Re: Inspection Item
Location: Lot 38 Cambridge Reserve (46 Atherton Circle Angier, NC)
JDS Project No.: RDU2505344
Date of Inspection: 05/21/25

A representative of JDS Consulting arrived on site to observe the issues reported to us by the client, which are presented, along with our recommendations, in this report.

**CRAWLSPACE SLAB FOUNDATION PLAN**  
SCALE: 3/16"=1'-0" ELEV. B

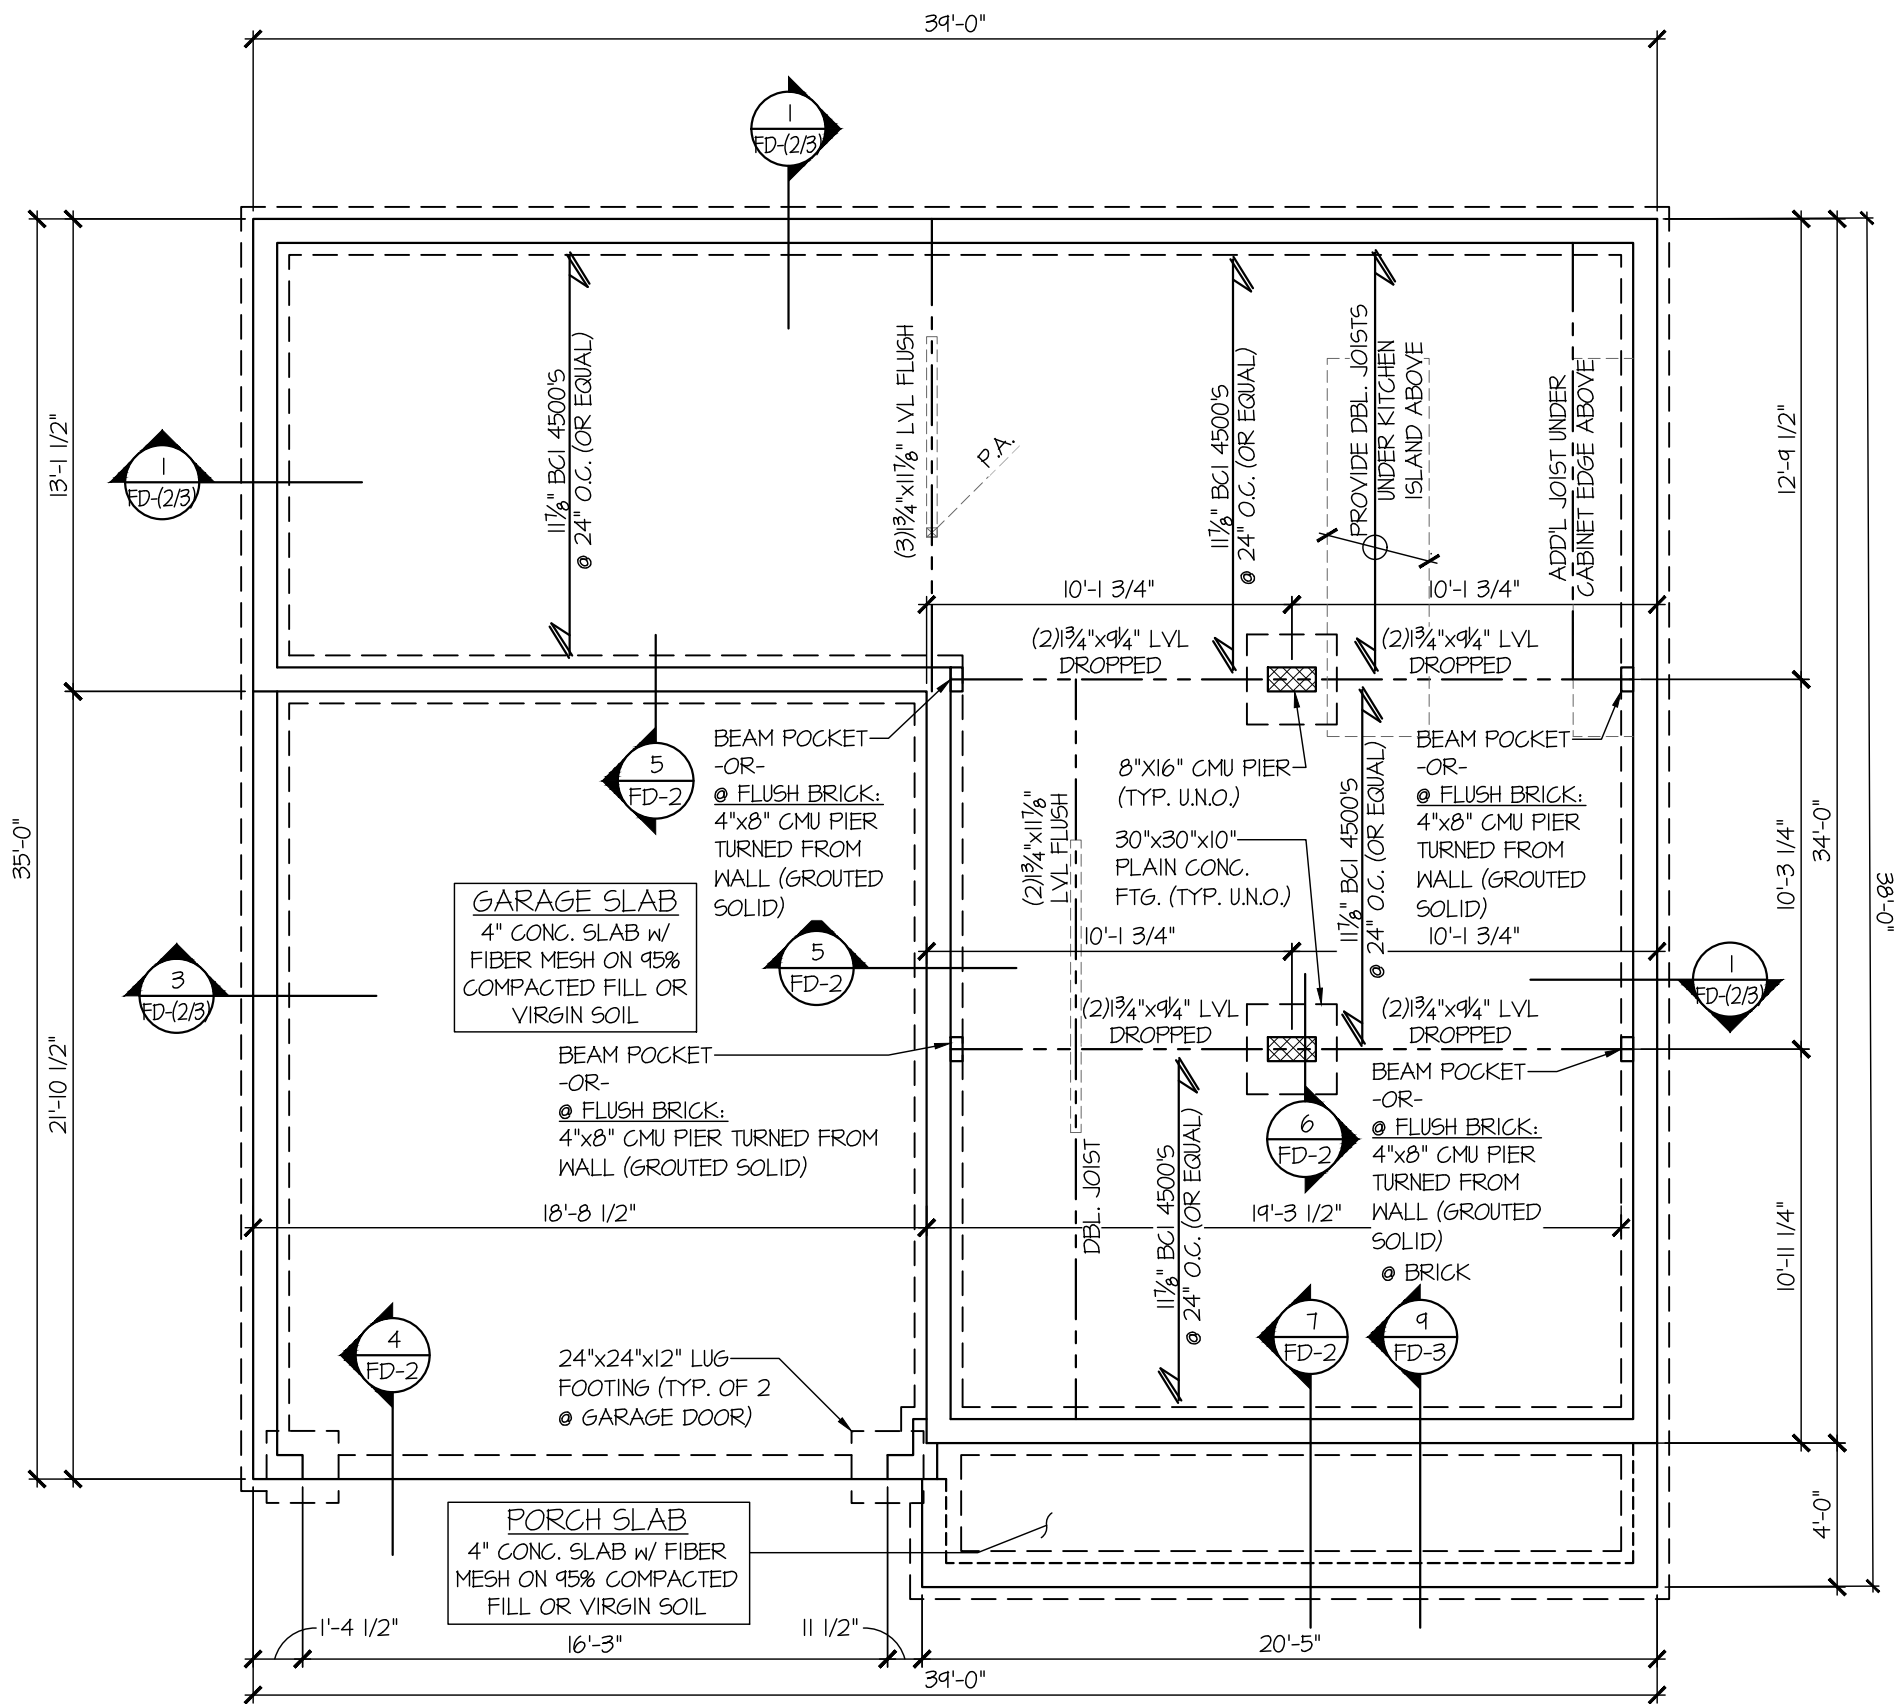
The inspector is questioning the girder beams in the crawl space. Inspector states that the LVL girder beams are not full bearing in the girder pockets. The rear LVL girder measures approximately 3" of bearing in the left girder pocket. The front LVL girder beam has approximately 2-1/2" of bearing in the pocket.

Based on our on-site observations and review, install 2x10 scabs on both sides spanning from the girder pocket out to the 1st pier attached with (4) rows of 10D nails spaced at 4" o.c. The client is to ensure that the 2x10 beams are fully inserted into the girder pocket. The client may trim the 2x10 as needed if needed to fit tightly into the girder pocket.
